**KIRKLEES METROPOLITAN COUNCIL
TOWN AND COUNTRY PLANNING ACT 1990
HIGHWAYS DEVELOPMENT CONTROL KP20H**

PLANNING REF 2016/62/92811/E0/LB
CATEGORY Small Major

PROPOSAL ERECTION OF 46 DWELLINGS AND ASSOCIATED WORKS INCLUDING ACCESS, PUBLIC OPEN SPACE, LANDSCAPING, PARKING AND ANCILLARY WORKS

LOCATION FLOCKTON HALL FARM,
BARNLEY ROAD,
FLOCKTON,
HUDDERSFIELD,
WF4 4DW

AutoTRACK Analysis of Access to Retained Farmland  
- Farm tractor & hay wagon

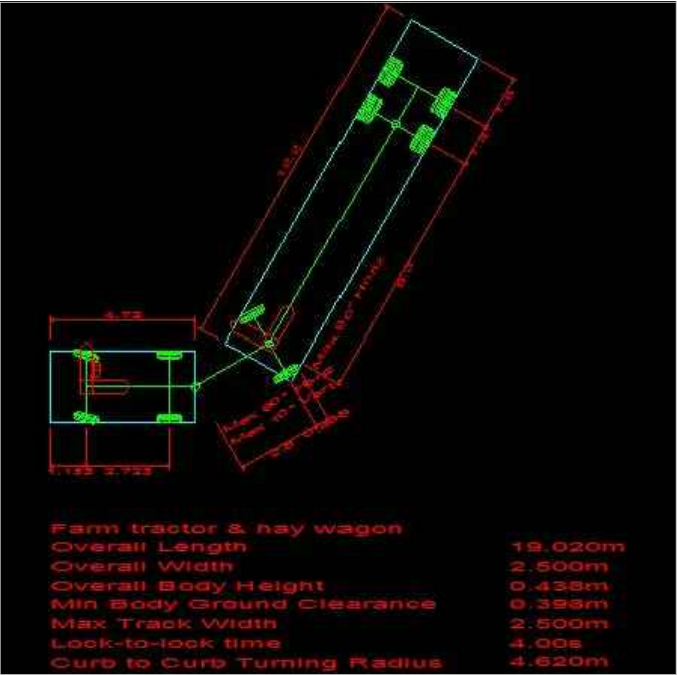
Right turners from the farm access may not be able to see traffic approaching from their left, due to eastbound vehicles queueing at the chicane.

A combined harvester and trailer cannot turn into the farm access without using the full width of Barnsley Road which will not be possible with vehicles standing on Barnsley Road at the stop line to the chicane.

Option 1 doesn't provide an acceptable access into the farm and option 2 removes the chicane which is considered unacceptable on highway safety grounds.

PLANNING LAYOUT

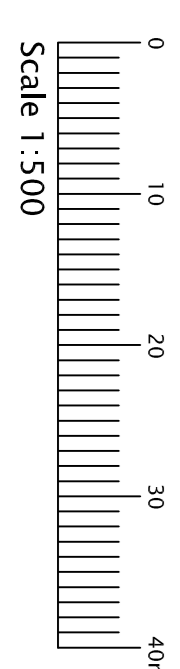
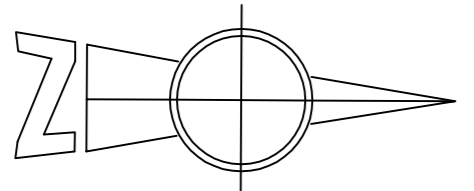
Plots 2, 14, 16,27,29,44 and 41 are four bedroom houses with only two off street parking spaces. These plots all need 3 off-street parking spaces.
Plots 5 to 7 have only one parking space. These plots all require 2 spaces.

Both turning heads are considered insufficient in size to comfortably turn an 11.6 metre refuse vehicle.

Plots 2, 14, 16,27,29,44 and 41 are four bedroom houses with only two off street parking spaces. These plots all need 3 off-street parking spaces.

Plots 5 to 7 have only one parking space. These plots all require 2 spaces.

Both turning heads are considered insufficient in size to comfortably turn an 11.6 metre refuse vehicle
